Winnemucca Lot Line Adjustment, VR-18-007

Please accept the following comments from El Paso County Public Health regarding the lot line vacation/replat project referenced above:

LOT 92 AND 93, UTE PASS SUMMER HOMES COMPANY SUB. NO. 1 AMENDED PLAT

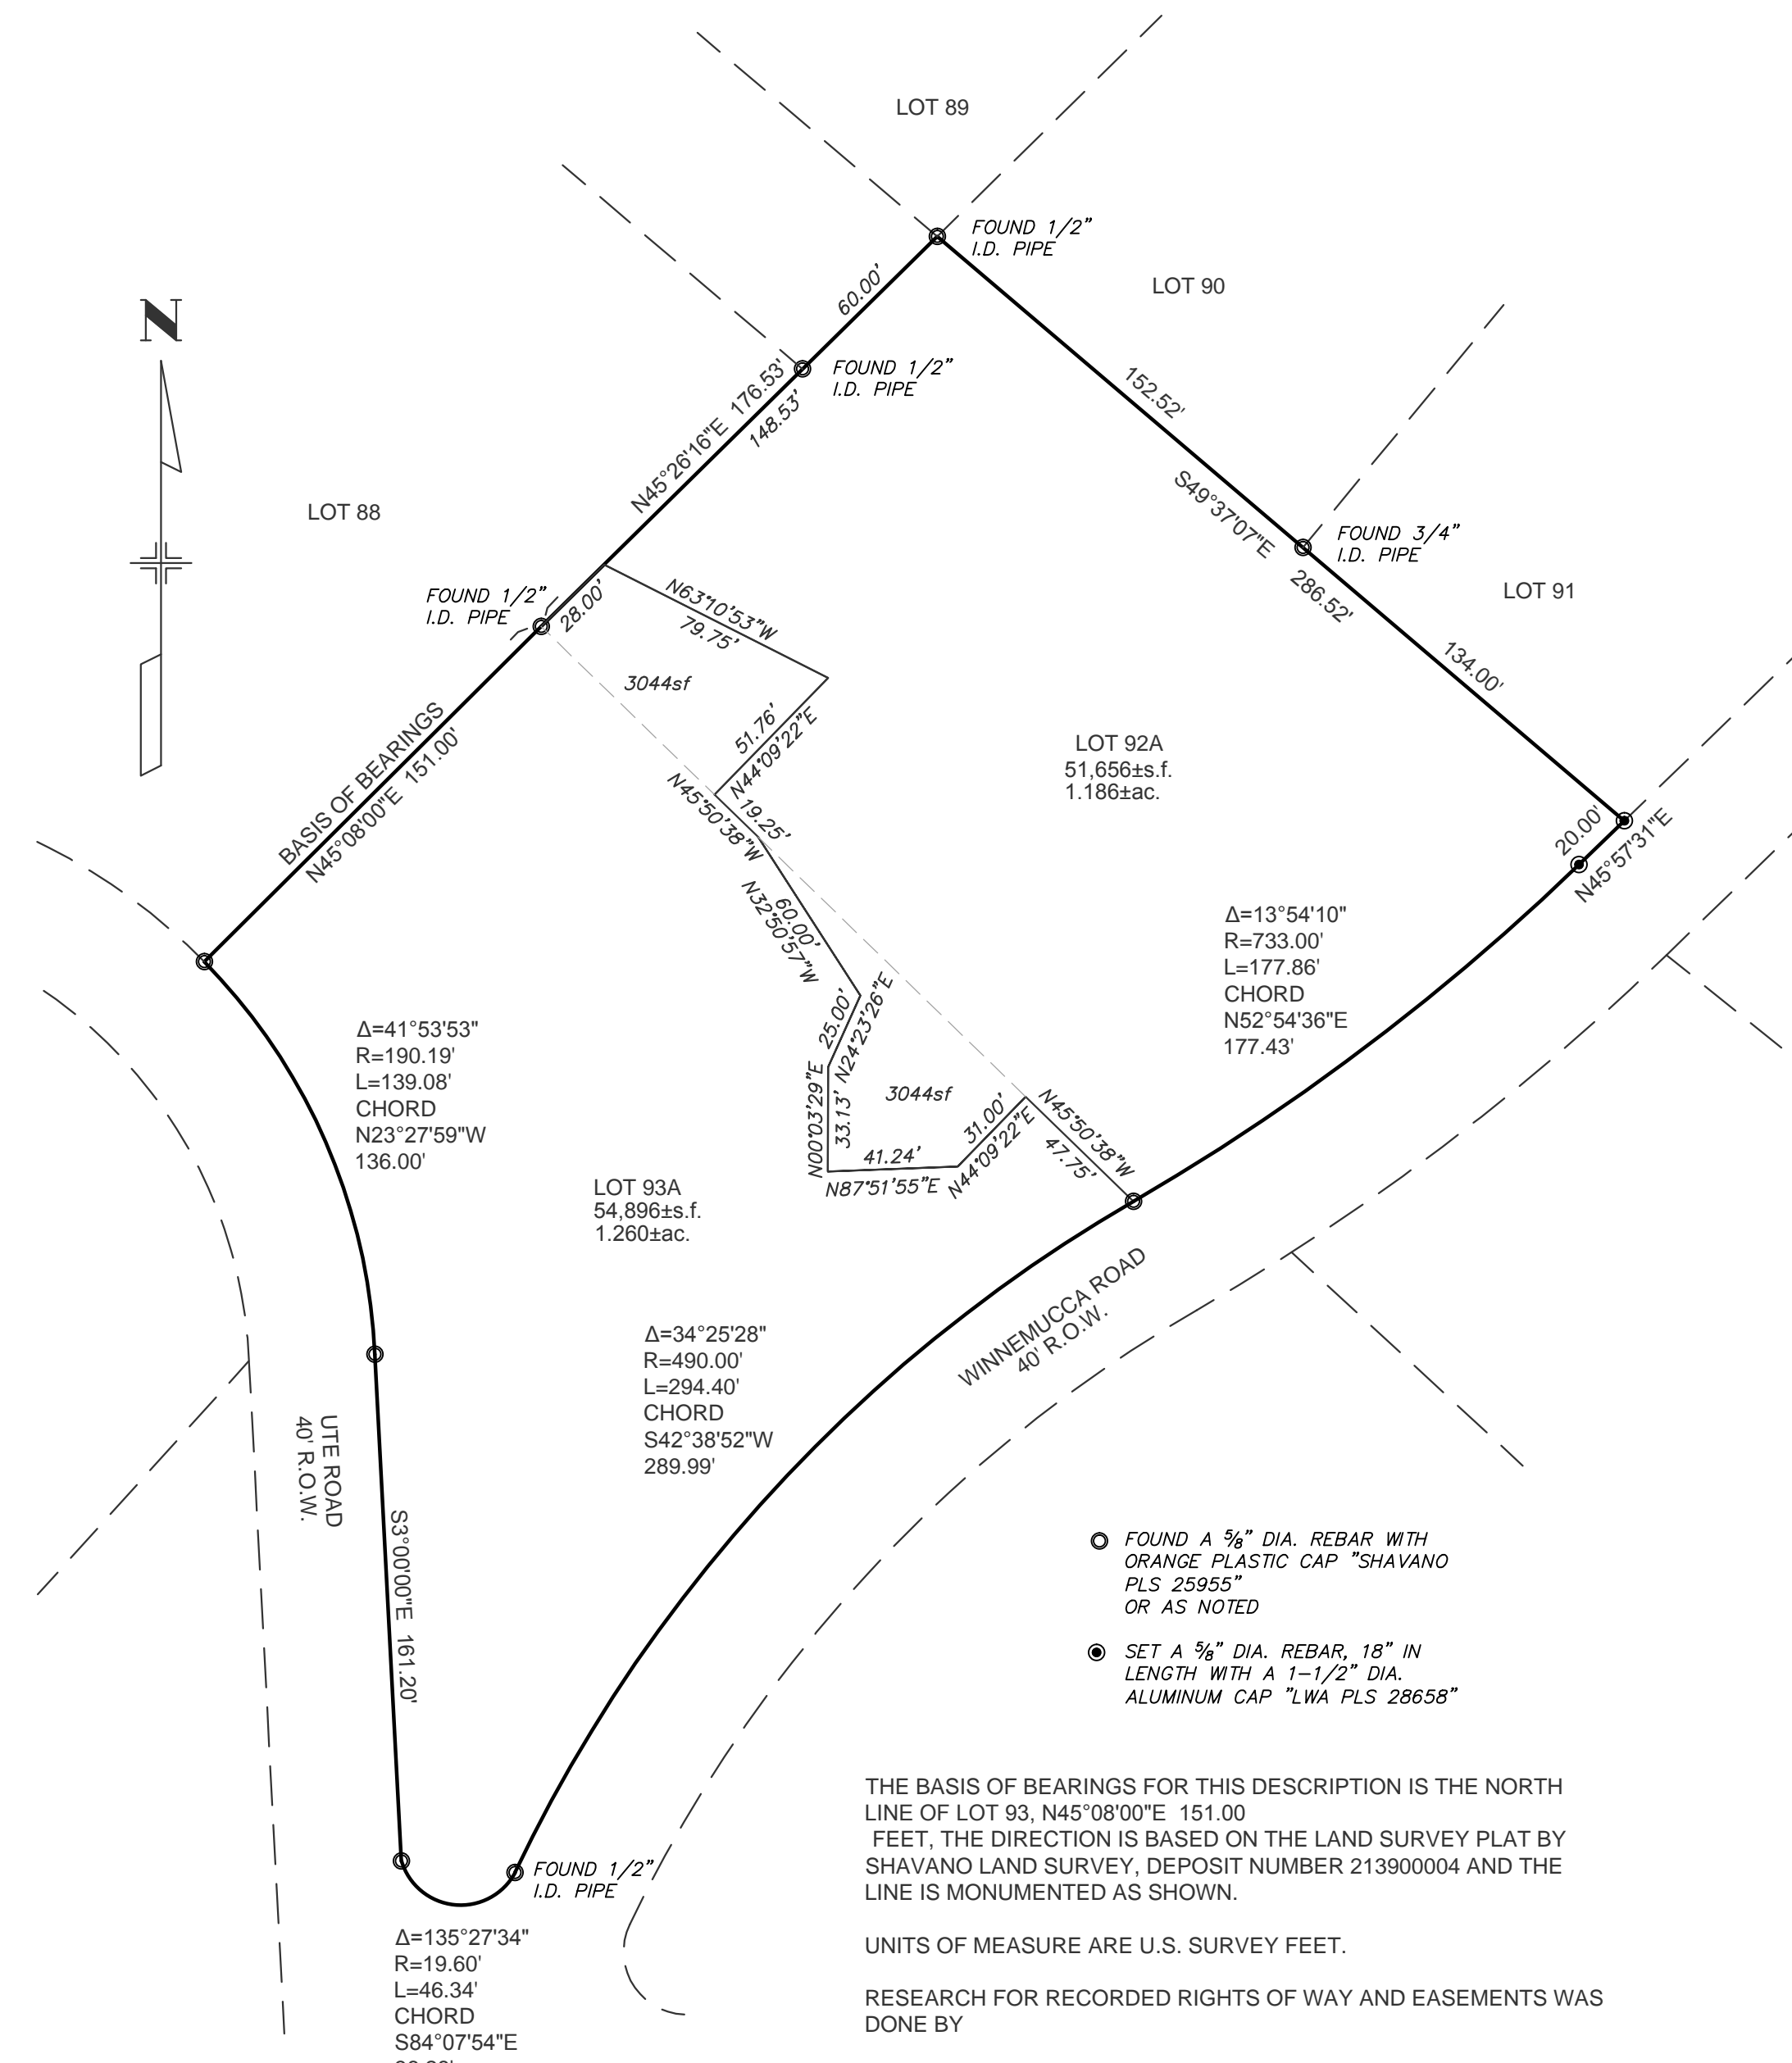
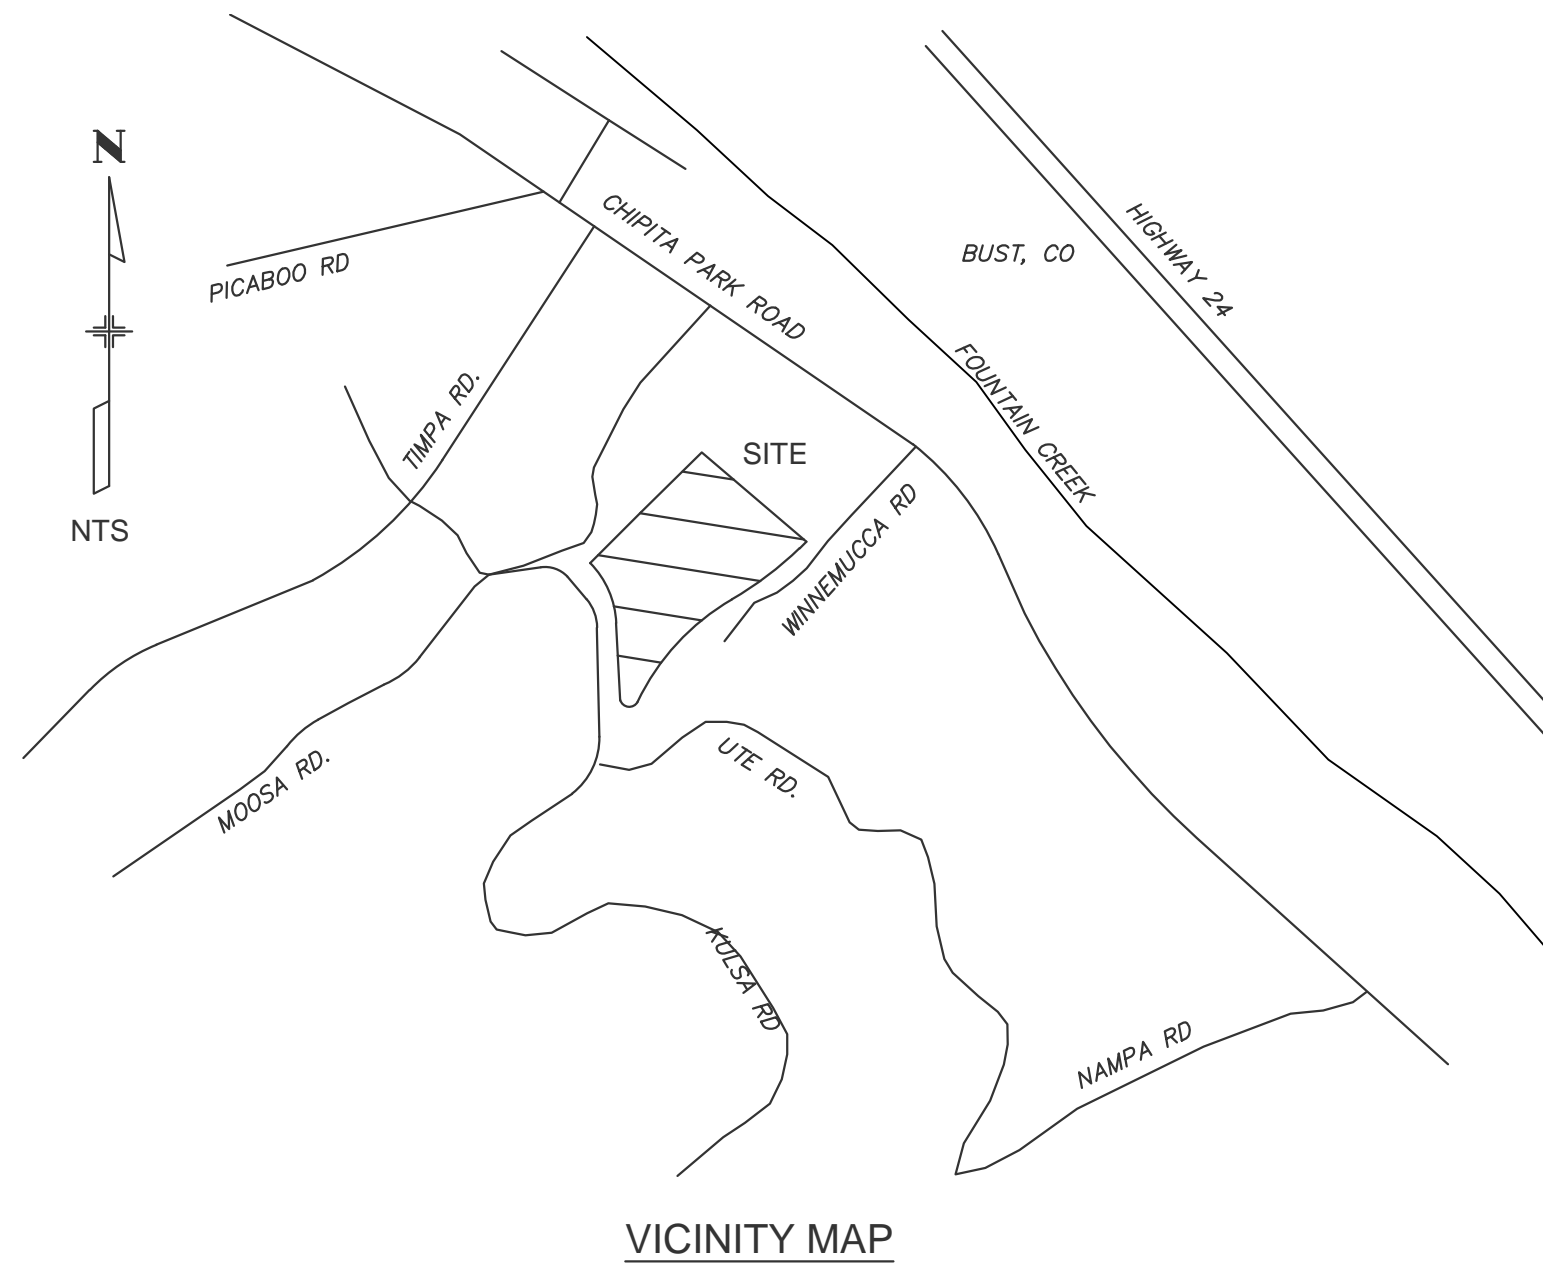
- El Paso County Public Health onsite wastewater treatment system (OWTS) records indicate each lot is served by its own approved OWTS. Drawings of where each OWTS is located can be found on the El Paso County Assessor's Office website at:
<http://land.elpasoco.com/default.aspx>

The El Paso County Public Health drawings of the two OWTS's are not to scale; therefore, it is advised that the exact location of the OWTS components be verified in the field to assure all components will be on the same lot as the structure it serves should the lot line vacation/replat be approved. There must be adequate lot area, also known as the secondary site, for the repair or the replacement of the soil treatment area (STA) should it ever fail in the future. Although there is an access easement agreement planned, the existing STA sites and the secondary sites shall be on the same lot as the structure they serve, and not within an easement.
